Submission No.			009	
Organisation Name or Name of Submitter			Andrew Conlon and Maeve Fitzpatrick (19 Berkeley Road, Phibsborough)	
Item No.	Section Ref.	Page No.	Observation Statement	TII Response
Letter Re: Observation on a Strategic Infrastructure Development Application				
1	Observation Details	1	<p>Our observations relate to the following areas:</p> <p>1. Project Governance and Consultation</p> <p>2. Negative impact of construction phase</p> <p>3. Design and layout of station</p> <p>4. Restoration and Operational Phase</p> <p>The observations should be read in the context of the duration and scale of the project and consequent exposure of residents near Mater Station to major disruption, including significant levels of noise and air pollution, for almost a decade.</p>	<p>Thank you for your submission and for sharing your observations with regards to the MetroLink project.</p> <p>As detailed in EIAR Chapter 5, MetroLink Construction Phase, the programme for the construction of the proposed Project has been optimised to minimise the duration of the Construction Phase in order to lessen the duration of potential environment impacts, while ensuring that the areas surrounding the

MATER STATION

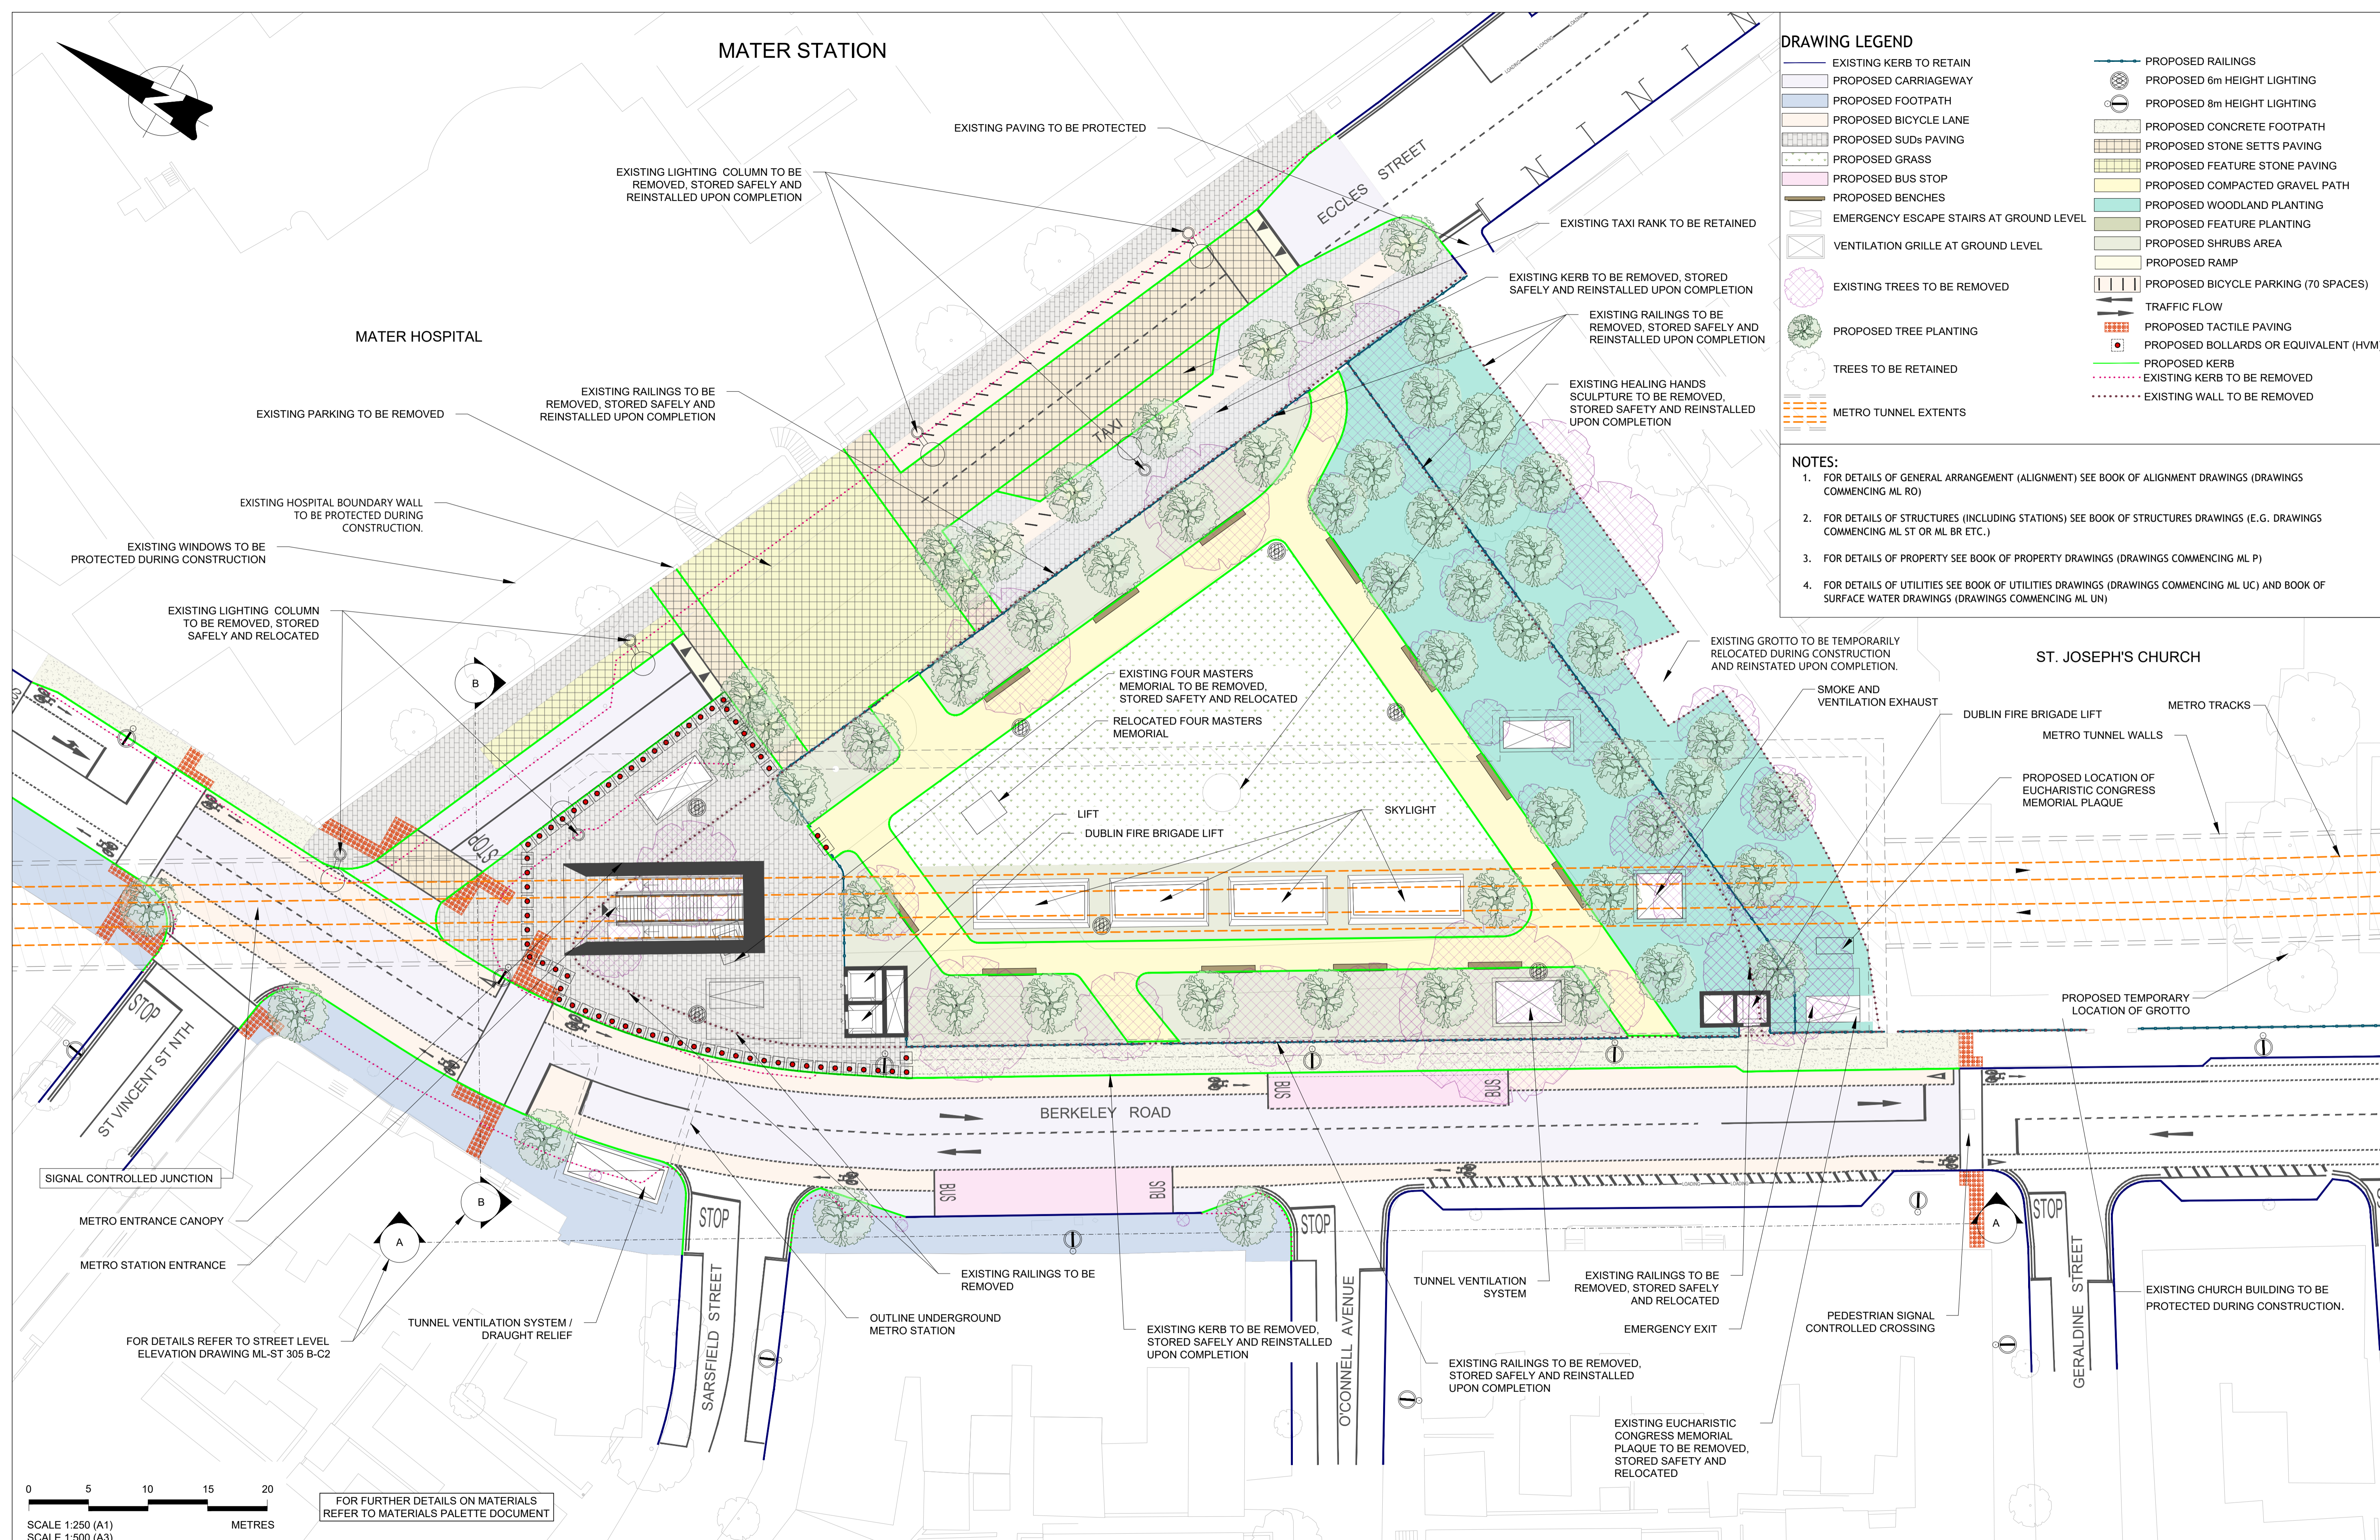
6	2. Construction Phase - Western Vent	2	<p>There are inconsistencies in the documentation with regard to the location of the vent - drawings in the relevant Appendix would suggest the site of this shaft is outside no 18 Berkeley Road, but the text of the EIAR refers to it being outside no's 20-21 Berkeley Road. Again, clarity would be helpful but in either case, the secondary construction site will be within 3.5 metres of our home for extended periods of time.</p> <p>Remedy Sought: a) That the western vent shaft be relocated to the Metro side of Berkeley Road.</p>	<p>On the western side of Berkeley Road and north of the junction with Sarsfield Street, a ventilation shaft will be constructed as part of the Mater Station under Berkeley Road, and in front of No 18 and 19. The footpath will be reinstated on completion, but the existing parking at this location will be removed. TII do not accept that there is inconsistency in respect to the location of the ventilation shaft.</p> <p>Ideally, and like the vast majority of the MetroLink deep stations, the ventilation shaft would be an integral part of the main structure. However, with limited space to build the station under the park and surrounding roads, a ventilation shaft located on the north west corner of the structure would protrude up into Berkeley Road, and therefore would require the road to be diverted permanently around it where there is limited space to do so. Its proposed location, whilst not ideal from the prospective of the impact on your property during construction and loss of a parking bay, will in the long term be a preferred location as it allows the streetscape to be returned to its pre-construction layout upon completion.</p>

17	3. Location and Design	6	There are no images of the Metro when closed so it is not clear whether the large canopy overhang on the Metro will provide a level of shelter which will be sufficient to encourage street drinkers to congregate.	<p>All of the stations on MetroLink are gate-secured closed outside of normal operating hours. The entrances to Mater station will be gated with grilles incorporated into the canopies which will be lowered and locked at the end of the operational day and opened in the morning. Additionally, outside of normal operating hours, the public lifts will not be available for use. Please refer to section 6.8.3.3 of EIAR Chapter 6: MetroLink Operations &amp; Maintenance.</p> <p>When open for operation, MetroLink has been designed as an open system for passengers, so that people can walk through the station and onto the platforms without obstruction. The PSDs (Platform Screen Doors) will stop people accessing the track from the stations. A security fence will be installed along the whole of the above ground sections of the railway and at the tunnel portals. One of the outcomes of the architectural and urban realm design is to discourage anti-social behaviour, for example through the attractive setting, use of public lighting, open sight-lines, and avoidance of areas where individuals and groups of people can hide. Vandalism and anti-social behaviour on the trains and within the stations will be observed through CCTV (Closed Circuit Television) and if required staff sent to manage the situation. The ACID (Access control and intrusion detection) system will also identify intruders trying to enter locations where unauthorised access is prohibited. Subject to a Data Protection Impact Assessment and compliance with the General Data Protection Regulation, there will be a single CCTV system and a single ACID system serving all stations, tunnels, substations, and depot, and managed from Dardistown Depot.</p>
